Response to Submissions Report

Bulli Hospital Aged Care Centre for Excellence

Located at 22 Hospital Road, Bulli
Lot 1 DP 175787 and Part Lot 1 DP 165903

9 June 2017

Project No	15617
Scale	1:500@A1
Date	13/02/2017
Drawn By	AJE
Checked By	LG
Drawing No	DA.01.0601
Revision	C

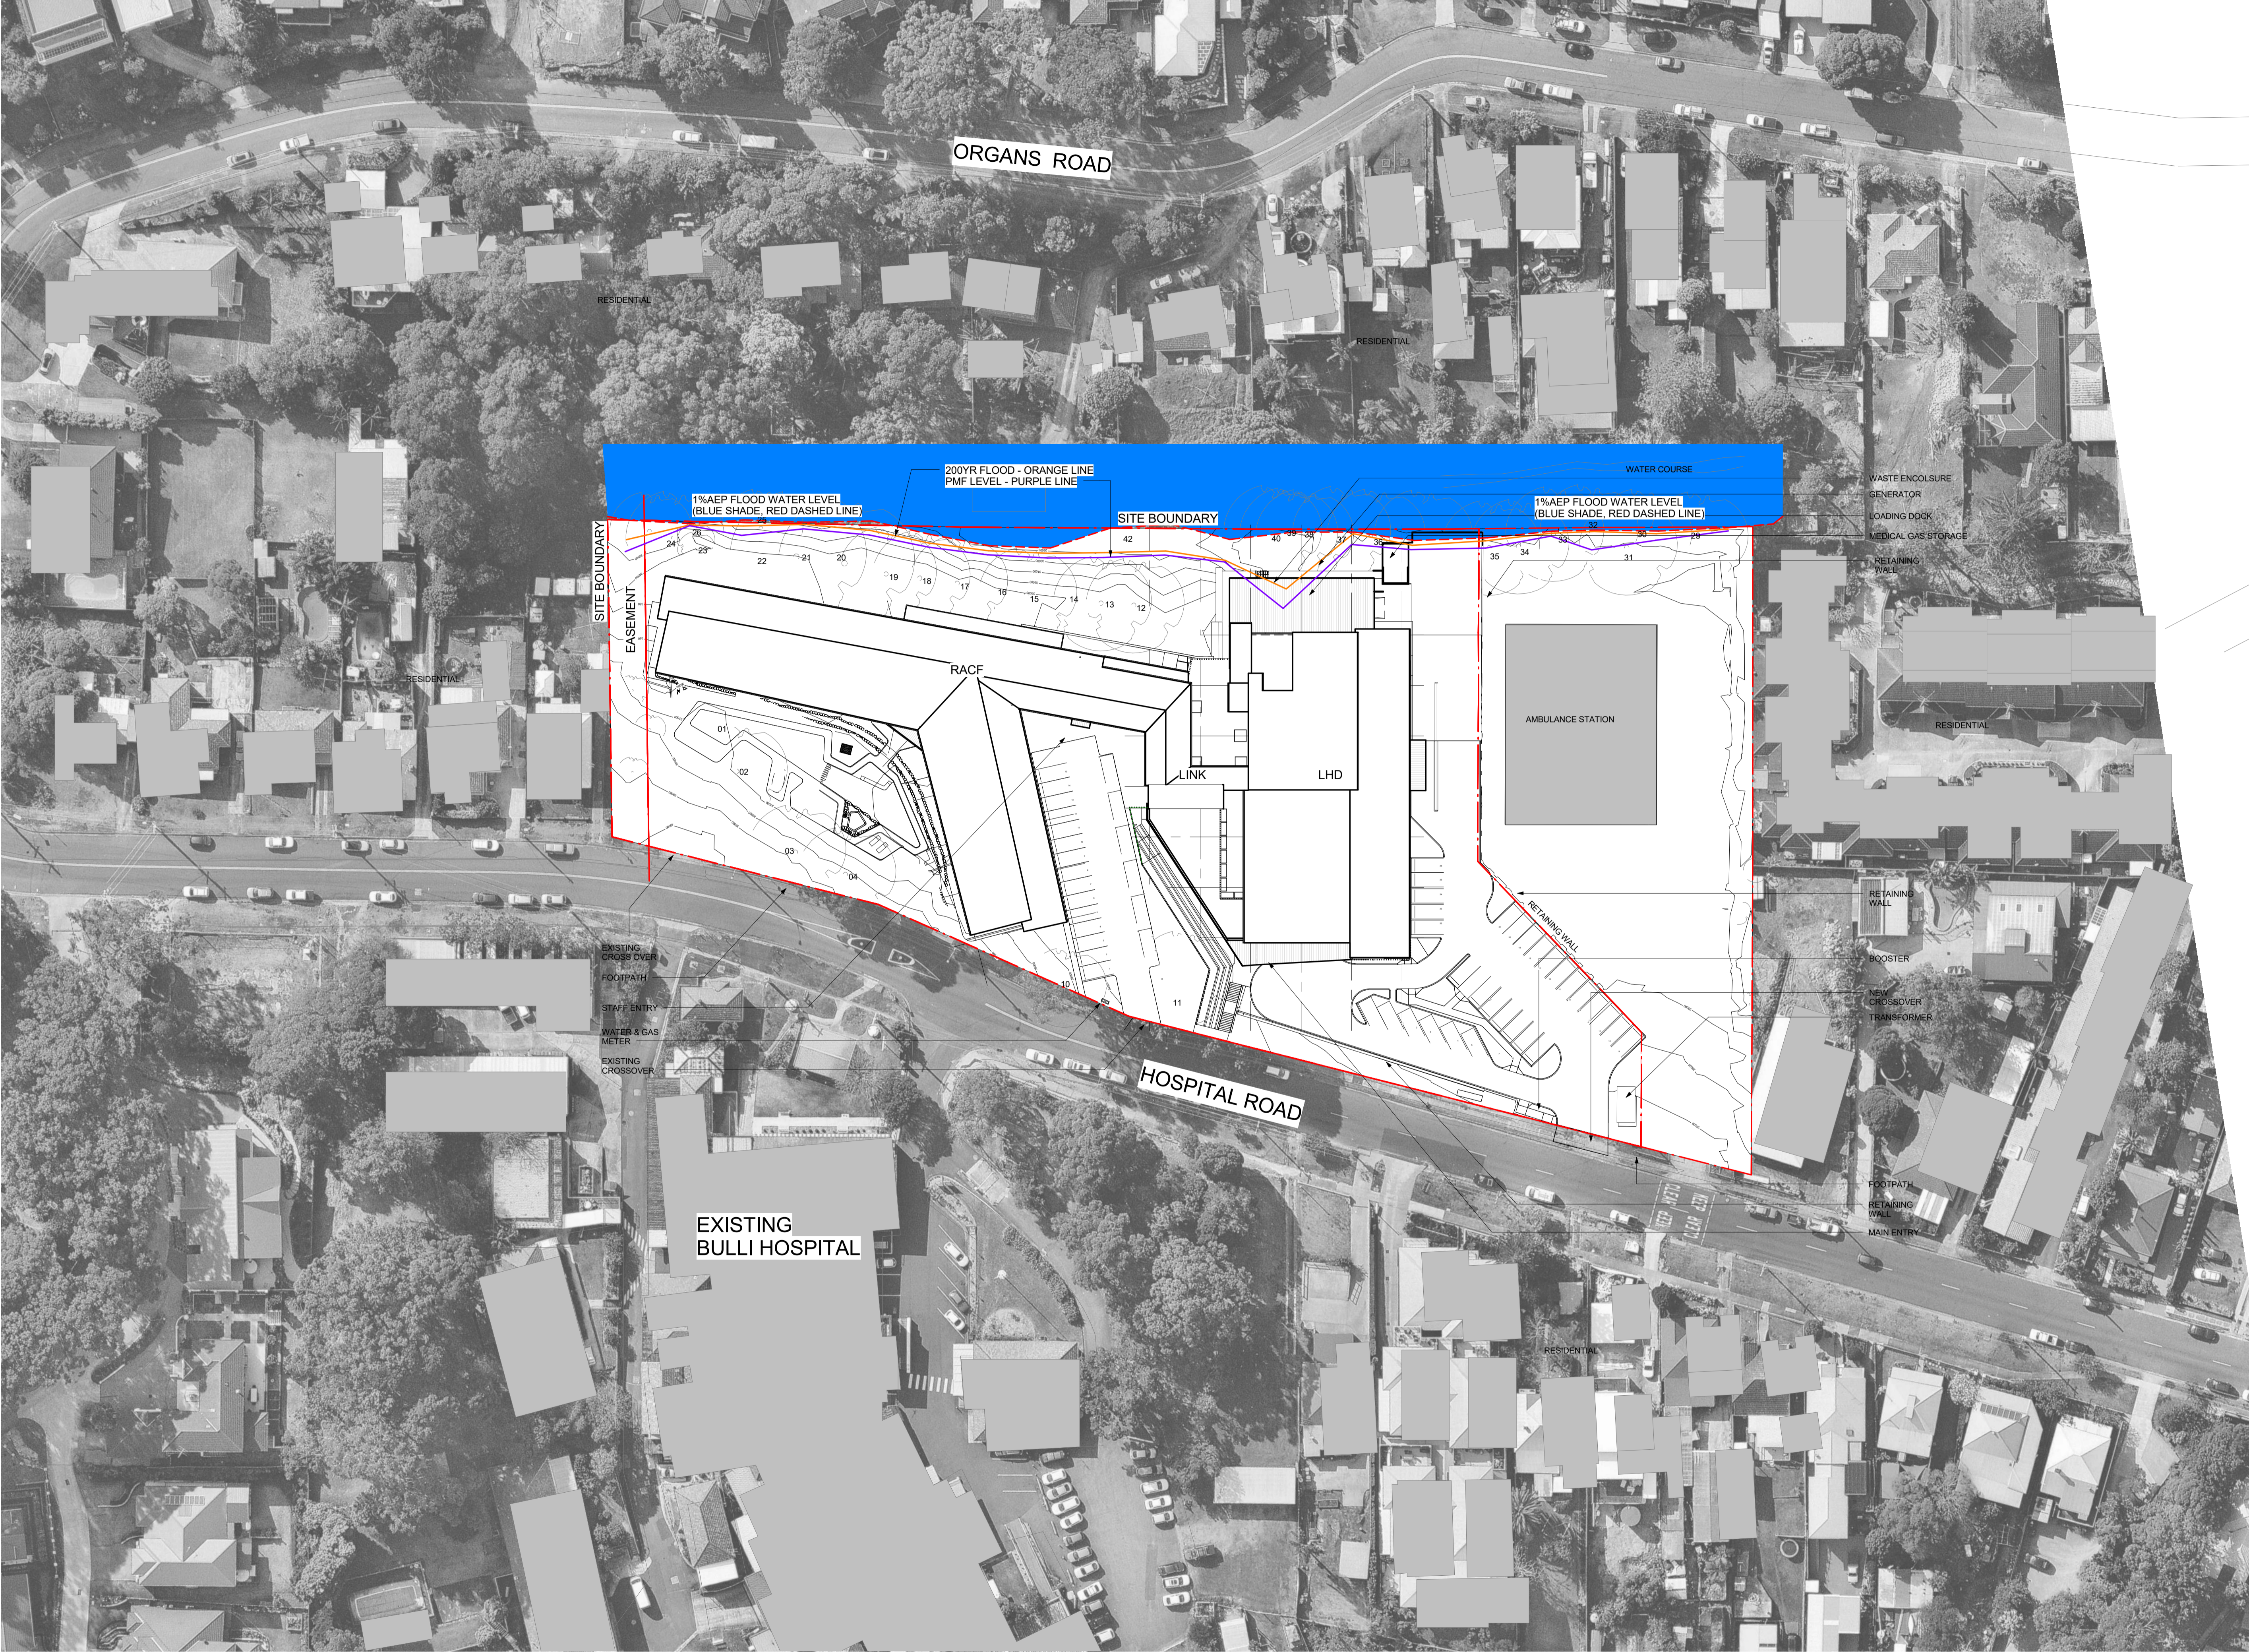
With respect to the request that the proposal should utilise the PMF the proponent advised that the PMF was not selected because it is large event (eg: 1:10000 year event) and the cost of constructing to this design level is prohibitive. A Flood Map Plan - 1% AEP Flood Water Level (Sheet DA.01.0601) contained in Appendix 1 demonstrates that the loading dock is the only portion that is below the PMF (by approximately 40mm). Further, only a portion of the loading dock is affected and the PMF will be diverted by a block wall on the northern side of the loading dock, which will protect the dock and services. Hence, there will be no need to evacuate the hospital in the event of an emergency.
